Your Ref :
Our Ref : LU/71/18/NMA

Non-material amendment following the grant of LU/251/15/PL for altered porches, arched heads to rear elevation with windows omitted, changes to materials of elevations, removal of chimney & rear door head details omitted.

Tulley Cottages, Toddington Lane, LITTLEHAMPTON,

Roof Plans

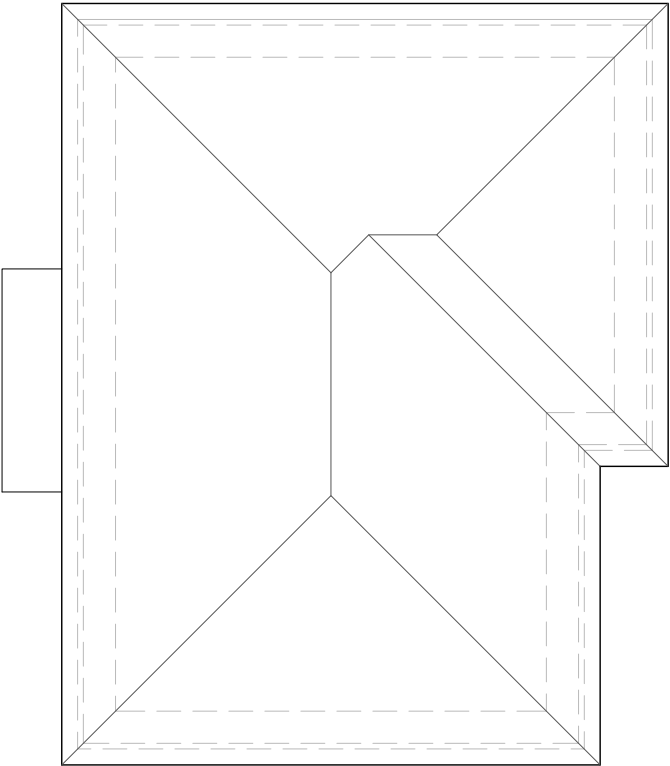
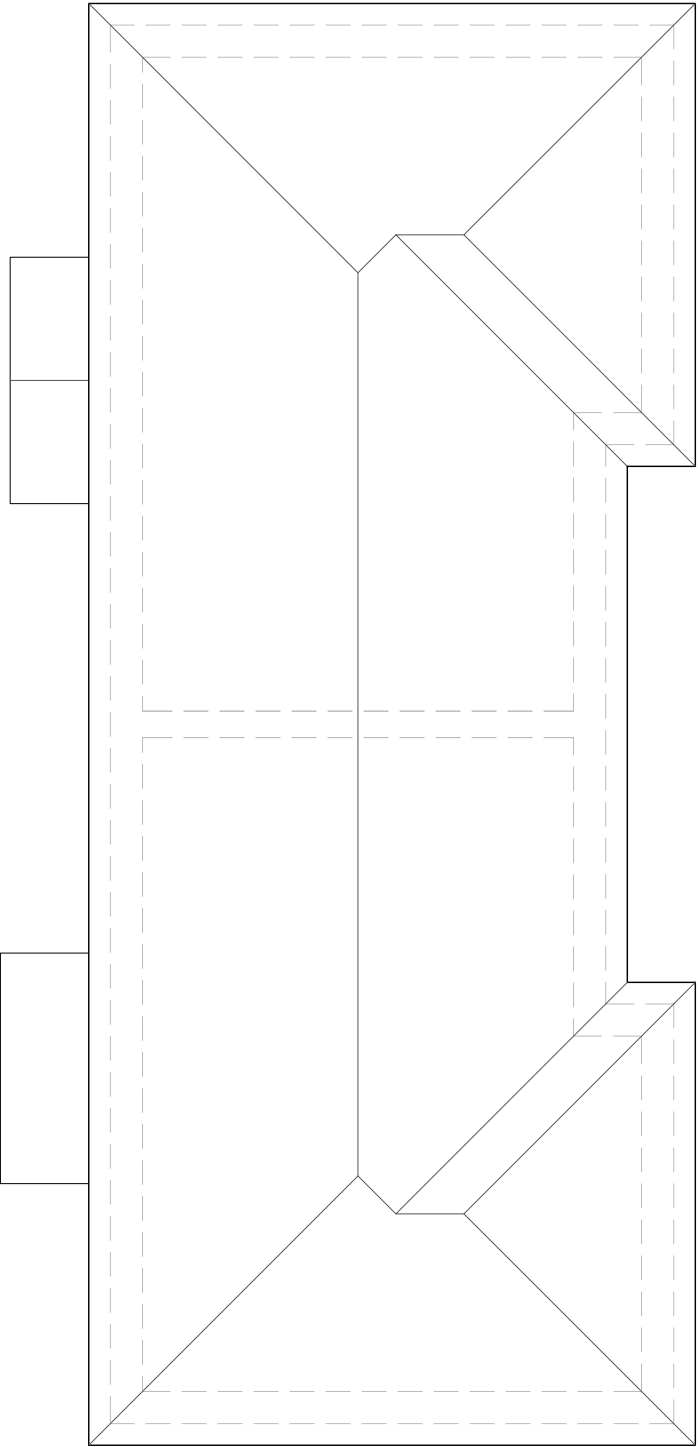
All three houses will be reduced in height by 1 metre from 8.5 metres to 7.5 metres.

- a) Remove chimney from scheme.
- b) Alter curved lintels above ground floor windows to the rear elevation
- c) Remove overhanging lintel from rear patio door.
- d) Insertion of brick patterning detail in centre of first floor front elevation.
- e) Alteration of curved top front door to rectangular shaped door and enlargement of window lights to side of front door from 20 cm wide to 40cm wide.

- a) Remove chimney from roof.

- a) Remove chimney from roof.
- b) Replace overhanging lintel on door with a pillared pitch roofed open porch with weatherboard triangular front elevation on roof.
- c) Remove overhanging lintel to rear elevation.
- d) Replace curved lintels with flat brick course lintels above the windows on front elevation at ground floor level.

17110.02.04 - Plot One, Two and Three Roof Plans dated January 2018.

Elevations

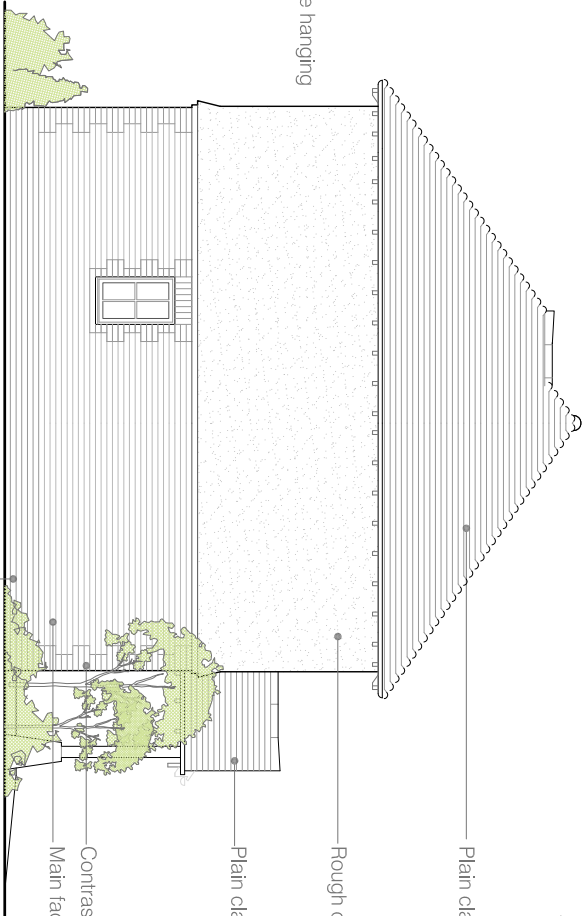
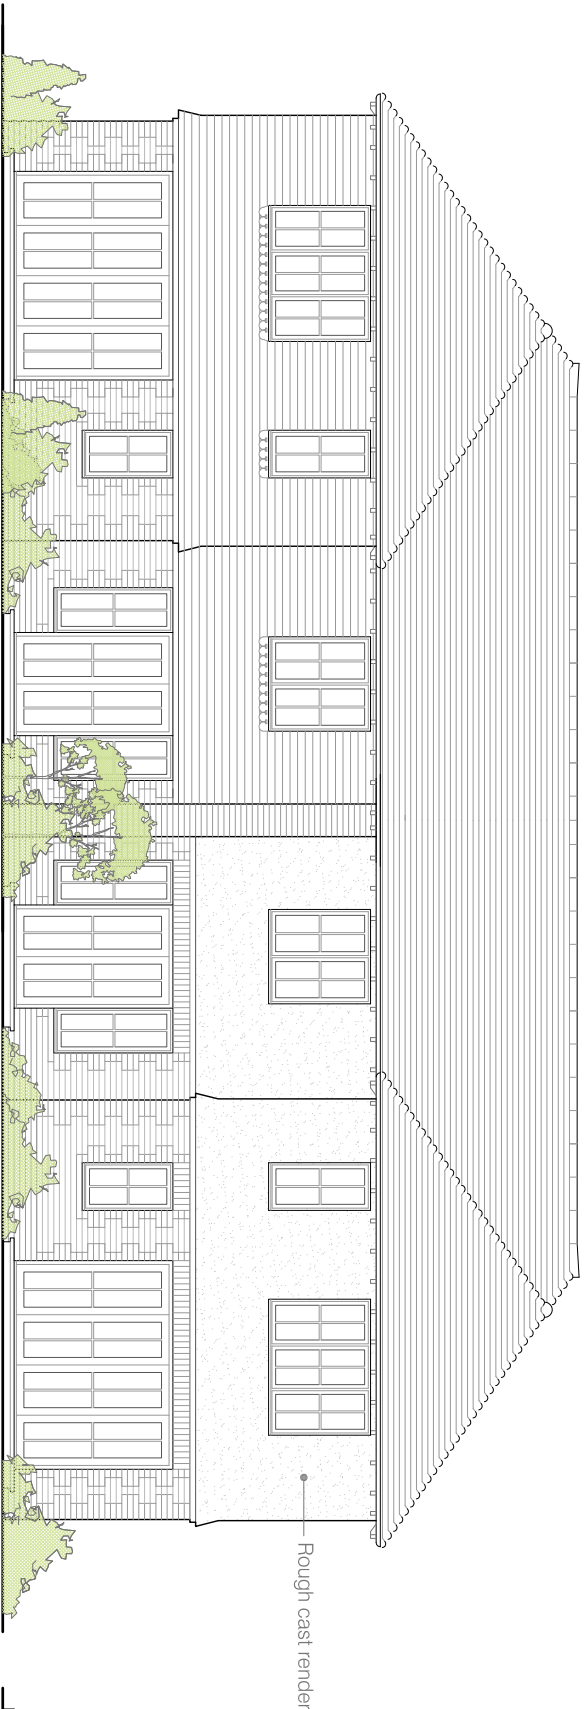
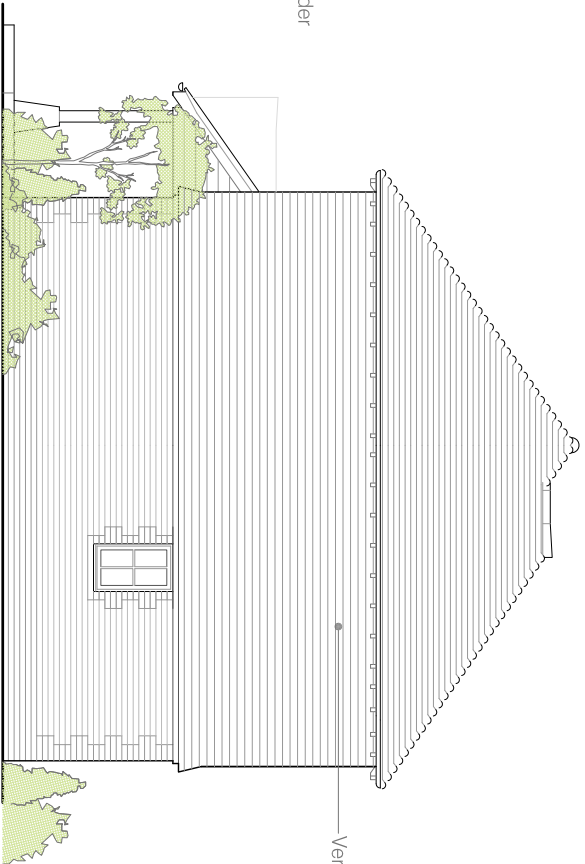
Unit 2

- b) Amend enclosed pitch roofed porch at front door to an overhanging lean to open porch supported by pillars.
- c) Insert brick course lintel above front lounge windows rather than clay tiles to the top of the window frames.
- d) At rear ground floor replace curved lintels with straight brick course lintels.
- e) Remove overhanging lintel and replace with flat brick course lintel.

Unit 3

17110.02.03 Rev B - Plots Two and Three Elevations dated 02/05/2018.

Floor Plans and Elevations

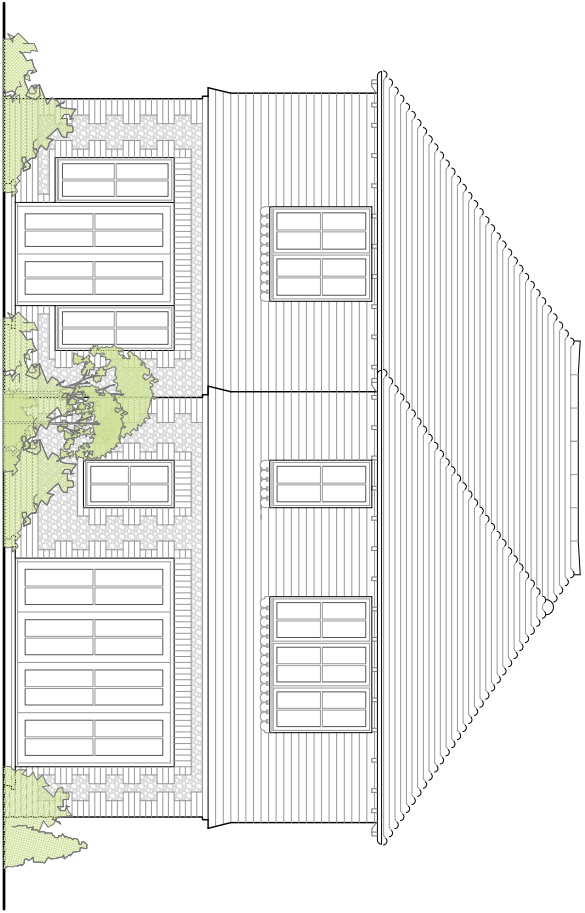
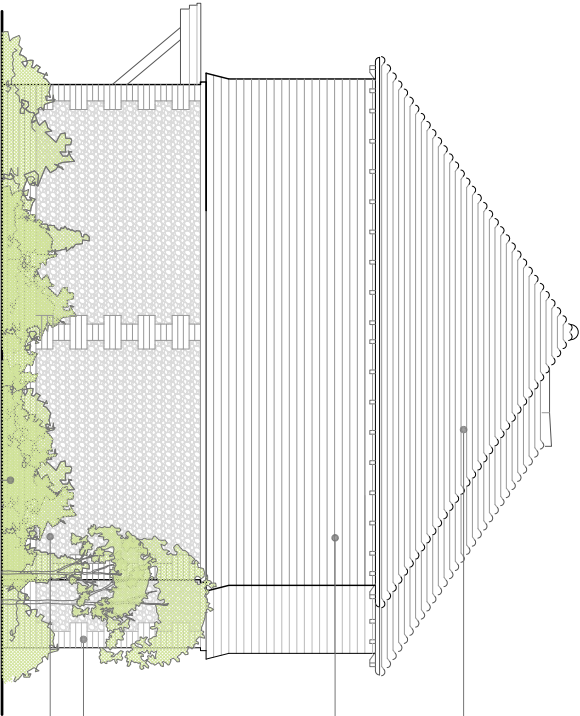
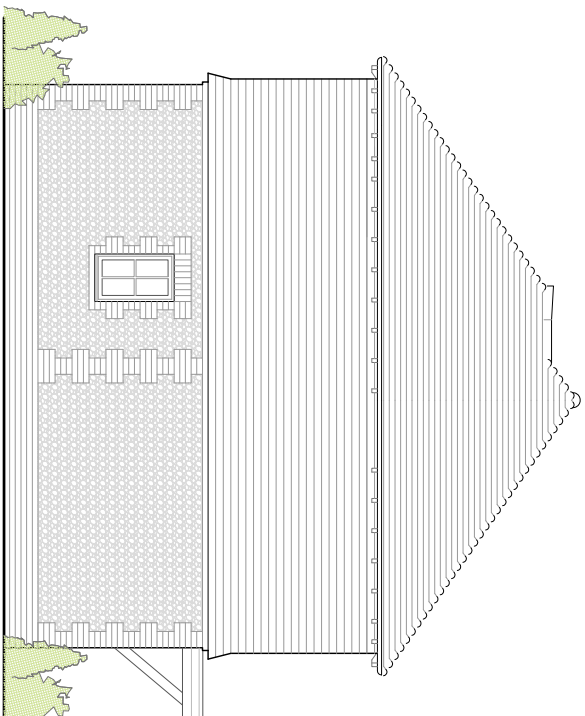
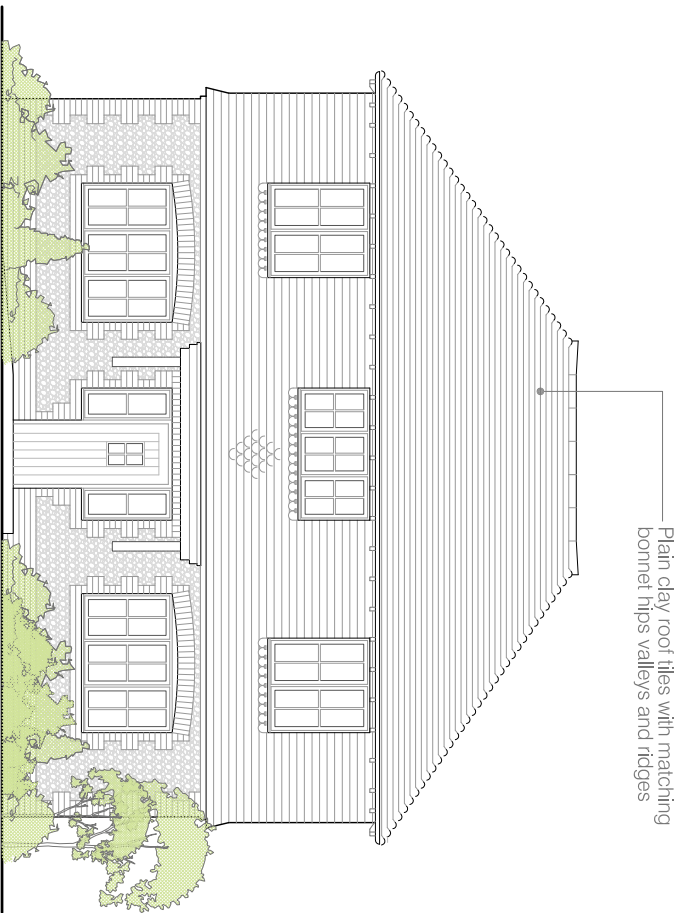
Unit 1

17110.02.06 Rev B Plot One - Floor Plans and Elevations dated 02/05/2018.
